CITY OF ALBUQUERQUE

DEVELOPMENT REVIEW BOARD MEETING –July 15, 2015

PARKS & RECREATION DEPARTMENT COMMENTS - Item #1

Project# 1000649 – Tract 84E, MRGCD Map #35

SHEET TITLE
PAD1 SITE PLAN FOR BUILDING PERMIT

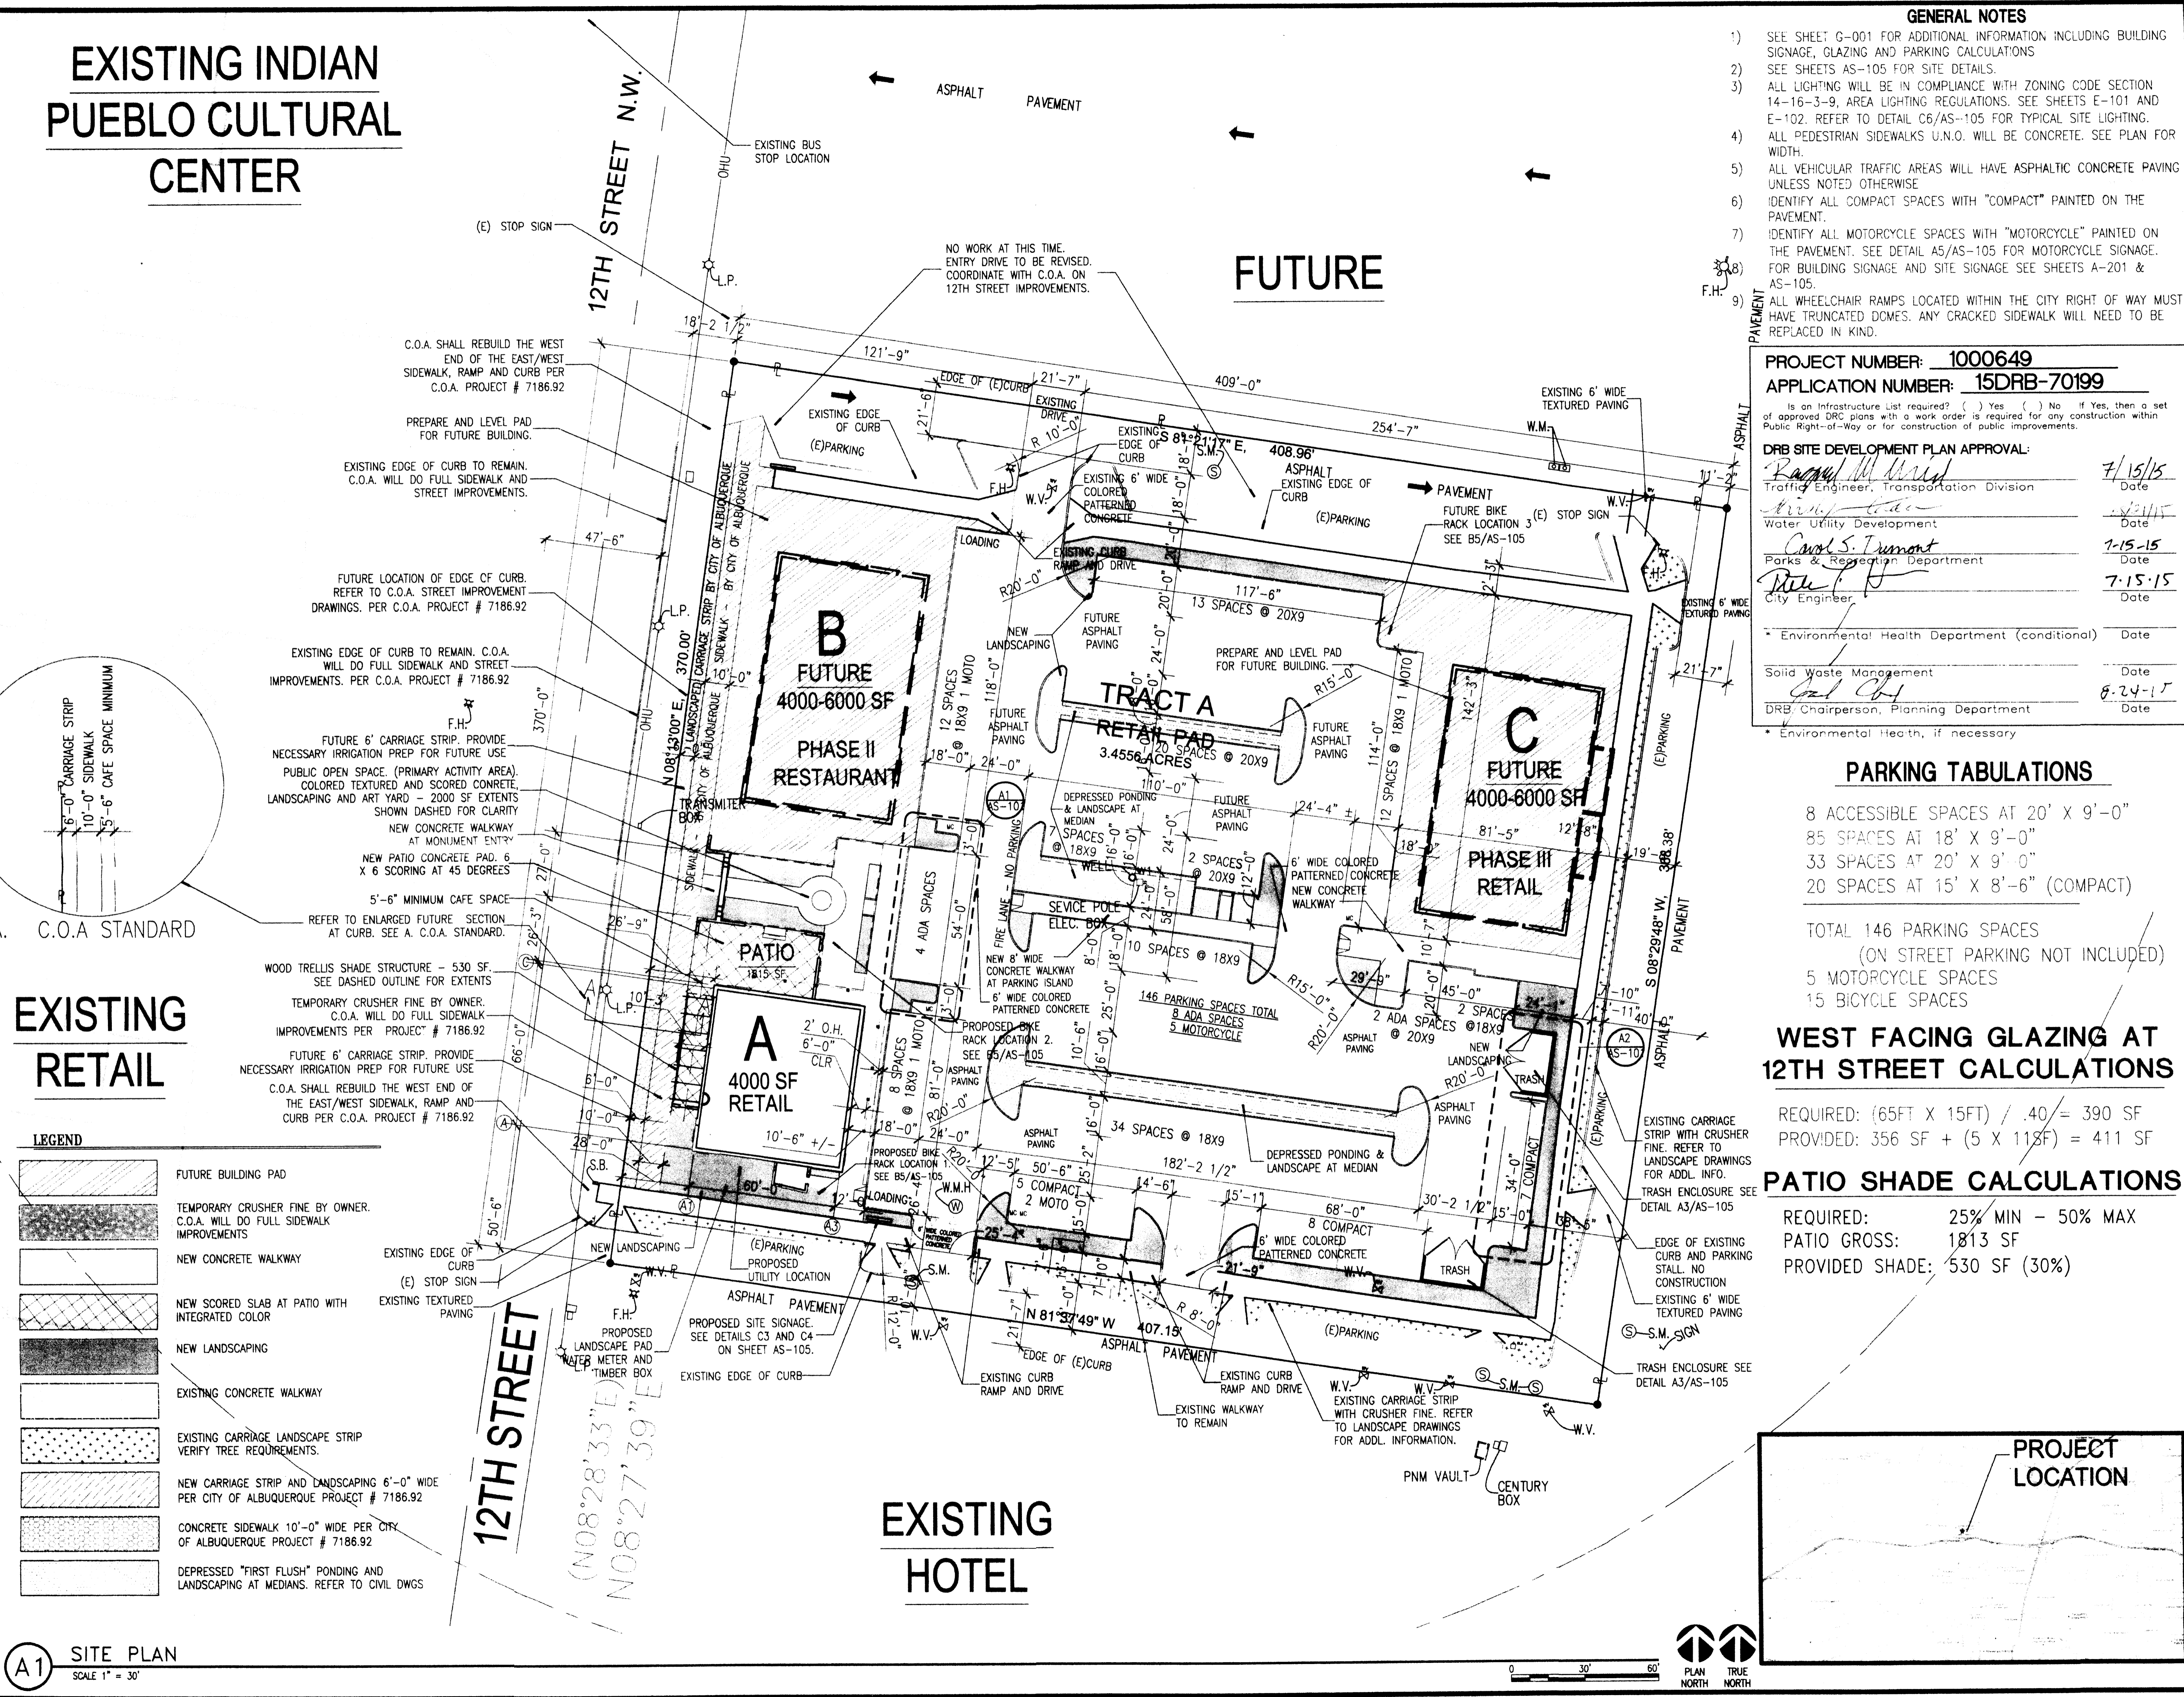
For clarification purposes, it is understood that the City DMD 12th Street Project will be responsible for the development of the curb, carriage strip and sidewalk along 12th Street. DMD will build to City Standards which includes a bubbler irrigation system, not a drip system.

The drip system indicated on the Plan is for the Starbuck site, not the 12th Street site and does not meet City Standards. It is recommended that it be reconsidered before development of the Starbucks parcel and associated landscaping.
